CITY OF ALBUQUERQUE

**Re: Boca Negra Dam LOMR
Engineer's Stamp Date –no seal or stamp- (D10D000)**

Based upon the information provided in your submittal received 5-11-15, the following comments are to be addressed:

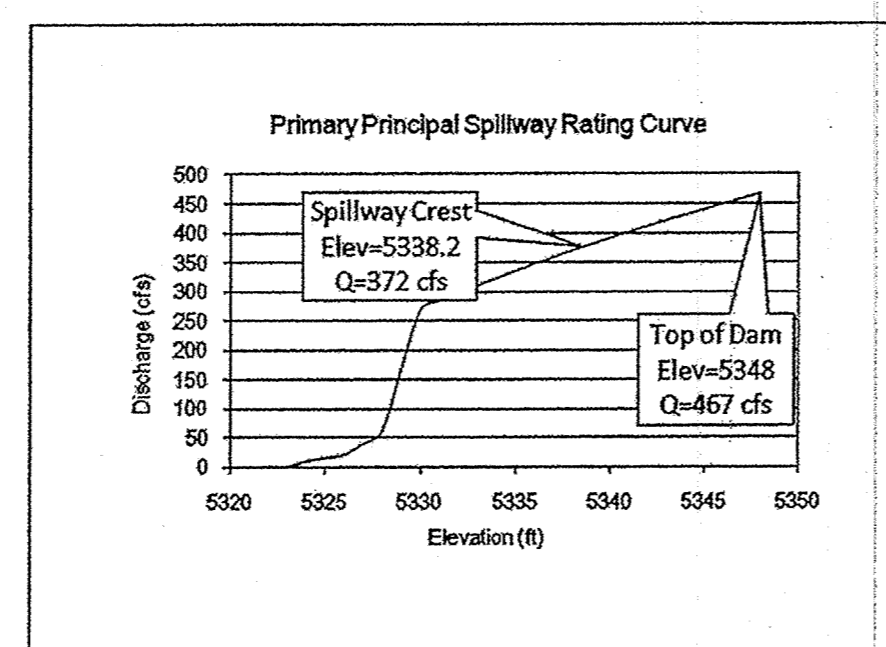
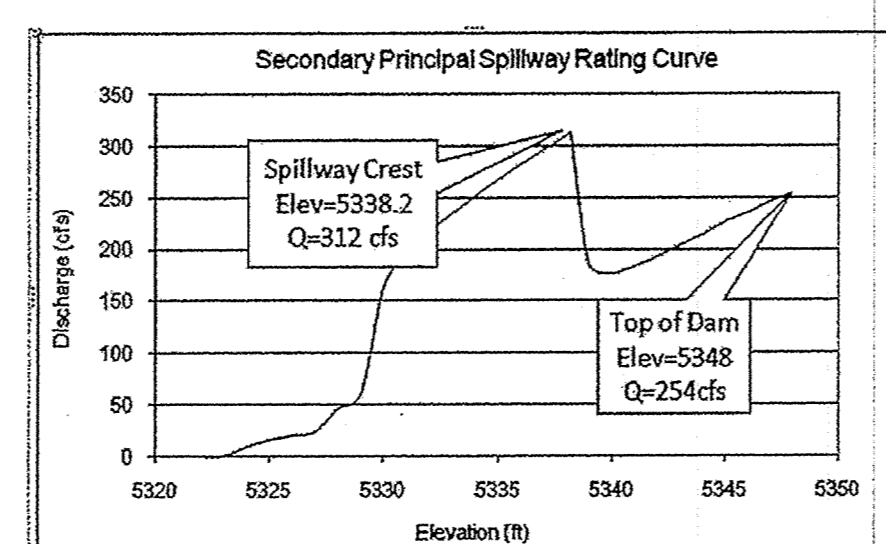
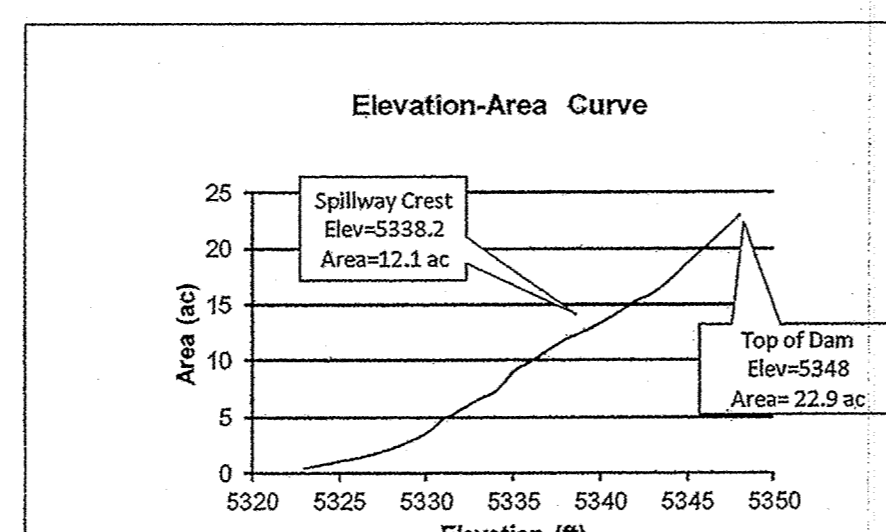
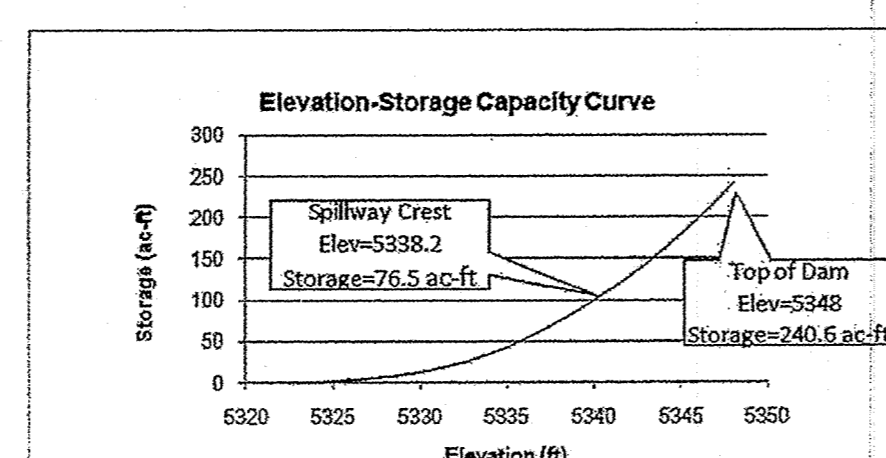
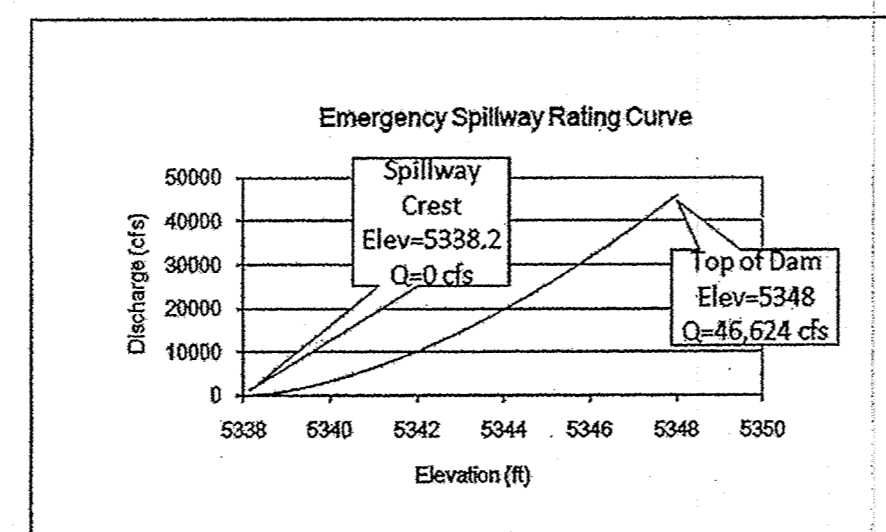
13. Provide stage-discharge curves/tables for the dam for initial design and as-built condition and how were they calculated (orifice equation)?

CITY OF ALBUQUERQUE
DEPARTMENT OF MUNICIPAL DEVELOPMENT
ENGINEERING DIVISION
SPECIAL ASSESSMENT DISTRICT 228 - VOL. 2
BOX CULVERT DETAILS

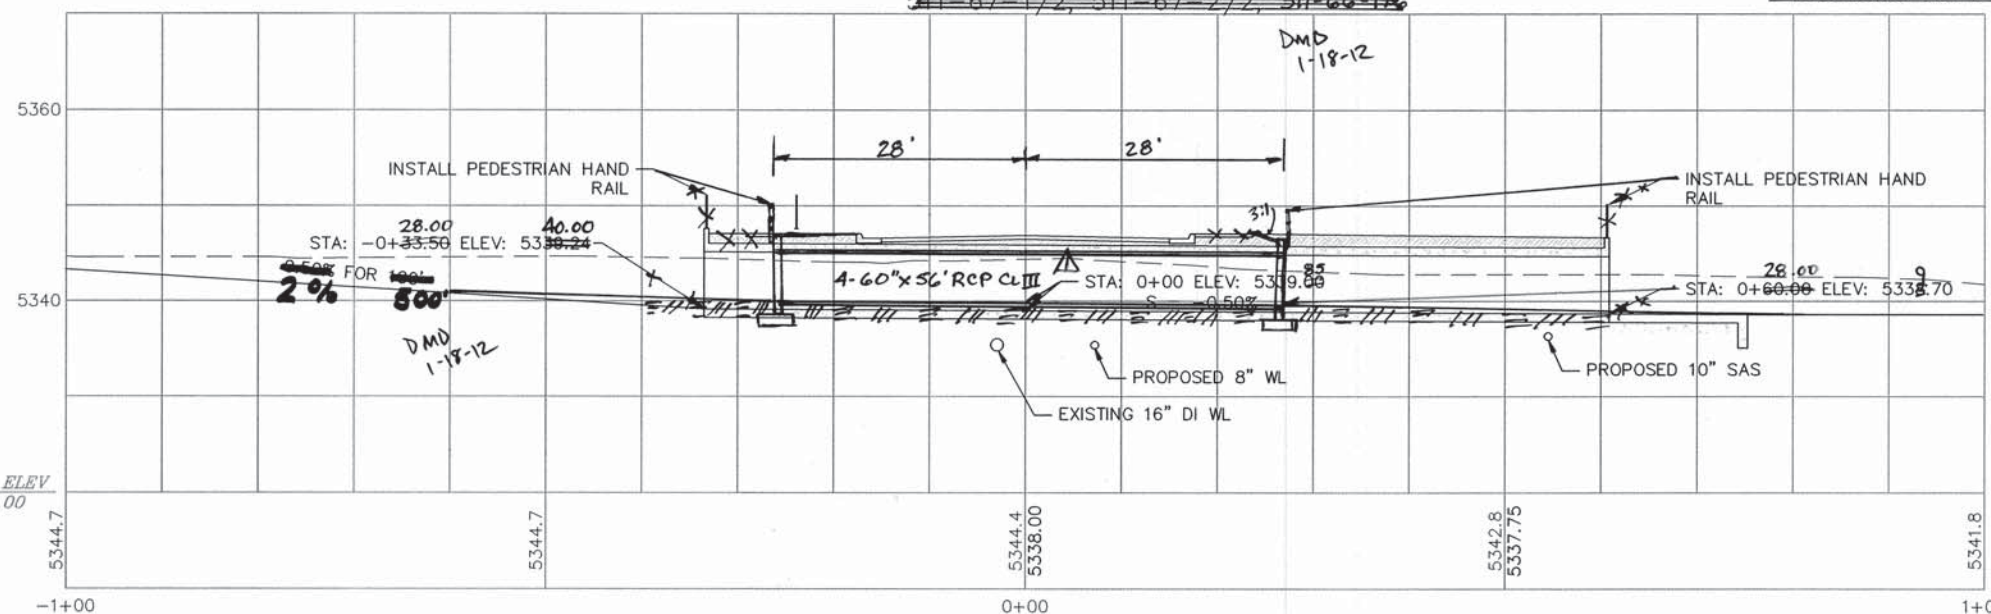
5. The HGL on Sheet 29 of the SAD 228 plans shows the HGL below the soffit. The LOMR states the water surface elevation is over the road. How did this occur? The same storm was used in the LOMR and the SAD 228 plans. Provide calculations and assumptions for the capacity of the culverts under Scenic Blvd.

10. Provide as-builts or field measurements of box culverts under San Idelfonso Rd and Tesuque Dr.
11. It appears there is a levee section on the north side of Mojave street. The flood zone should probably extend north of the channel bank in this area to avoid this being a levee.

CROSS SECTION SURVEY MAP

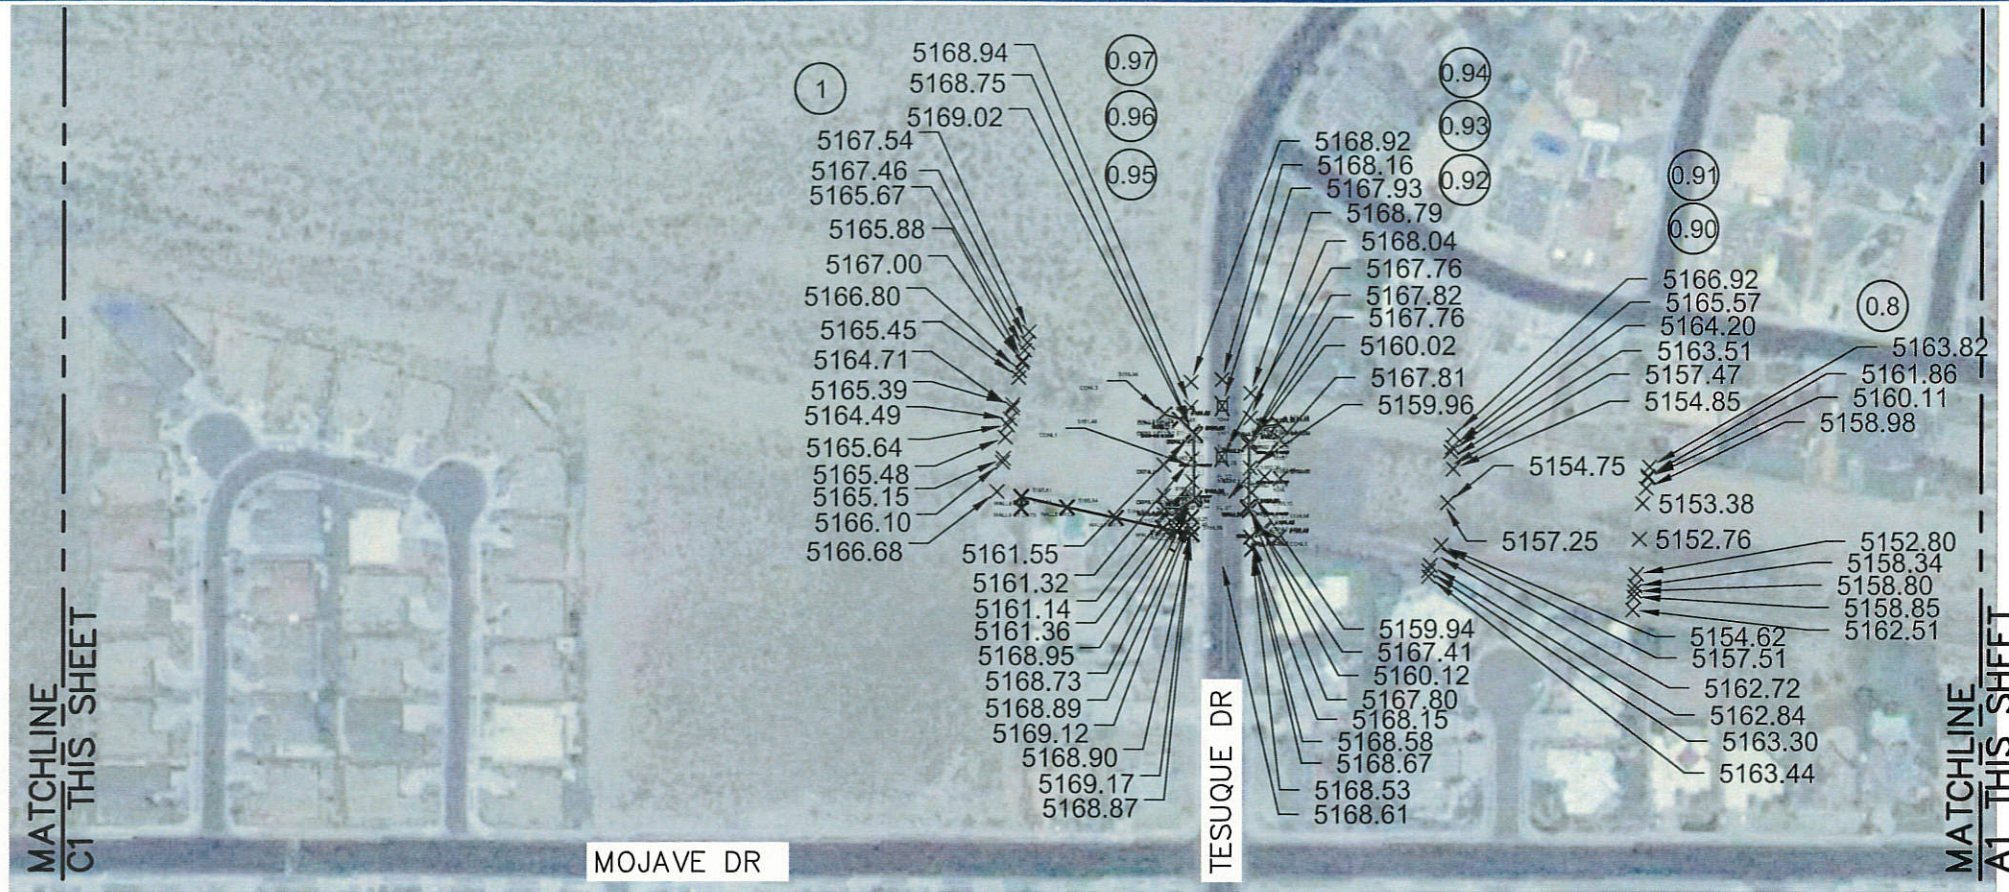
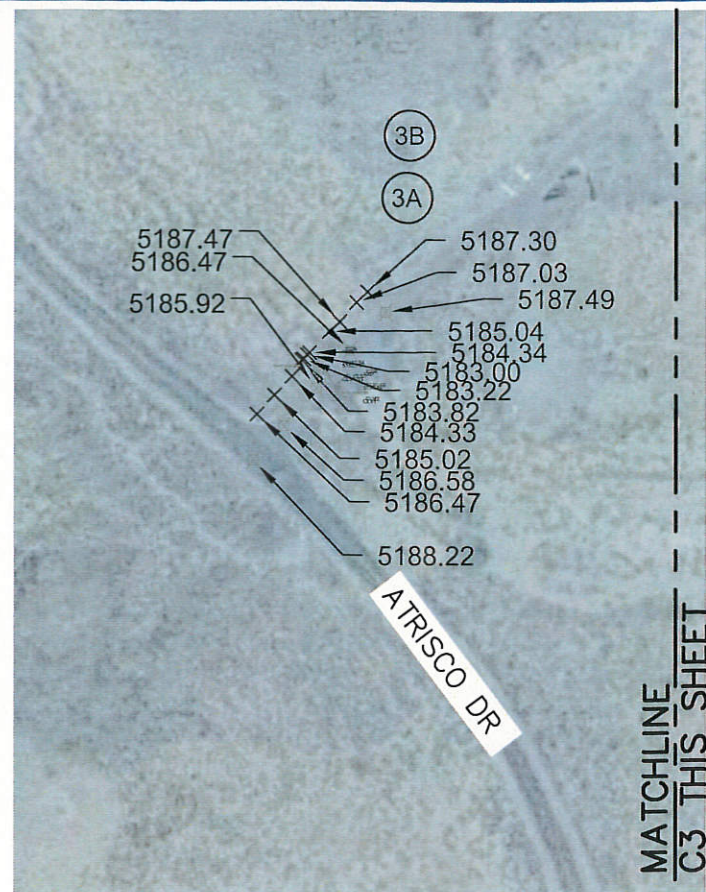
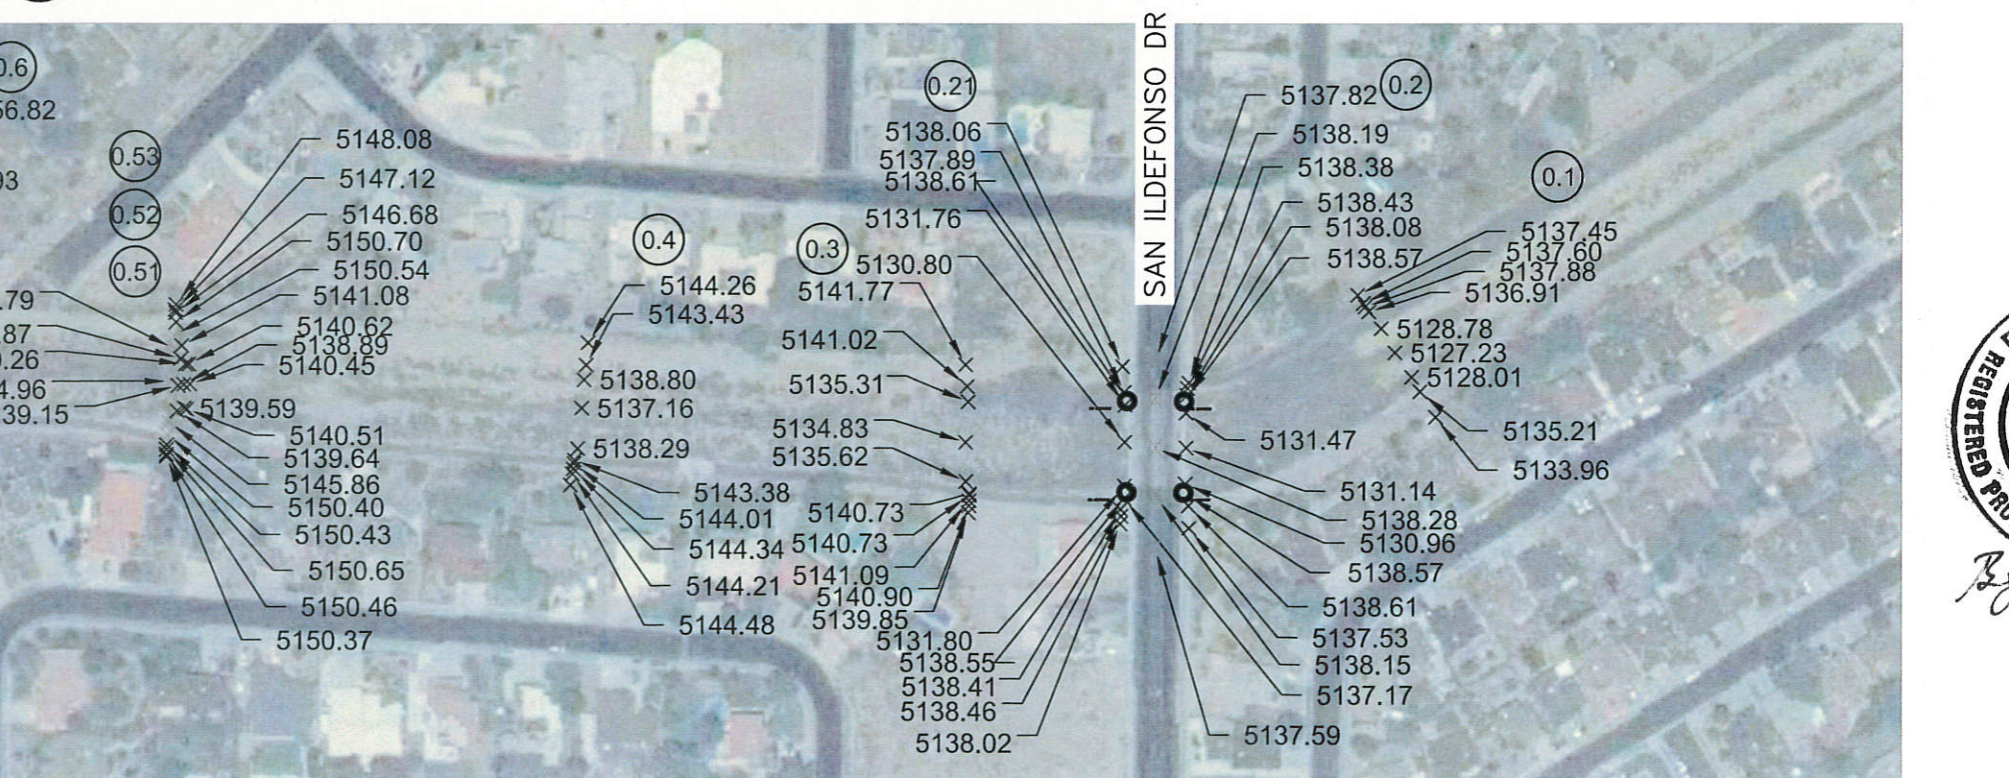
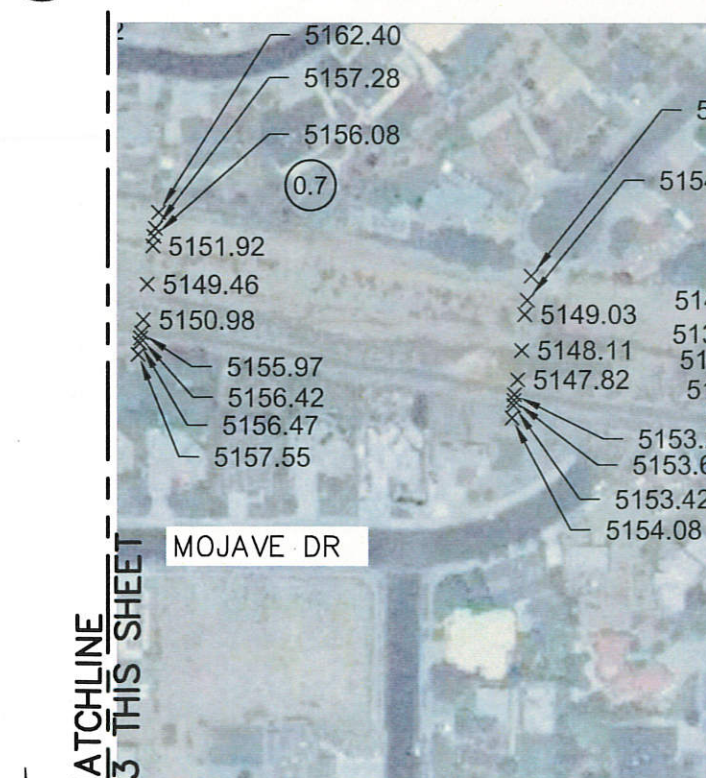
14. What sheet shows the as-built principal spillway riser details?
15. On what sheet of the AHYMO run can I find the HGL of the dam?
16. Proof (construction plan or core) of filled-cells is required for retaining walls to be counted as flood walls.
17. The Work Map and Annotated FIRM should reflect LOMR 09-06-2899P 3-25-10. The Flood Zone on Vista Vieja has been revised for 5 years.
18. The grade near section 13 appears to be 2 feet higher on the west side of the arroyo. Was this area surveyed?
19. The Maintenance Plan does not mention the channel downstream of the dam.
20. The City has concerns with the revised floodplain(s) encroaching further onto private property than the effective FIRM.
21. This was not a final review. The above listed items are to be satisfactorily addressed, before continuing the review.
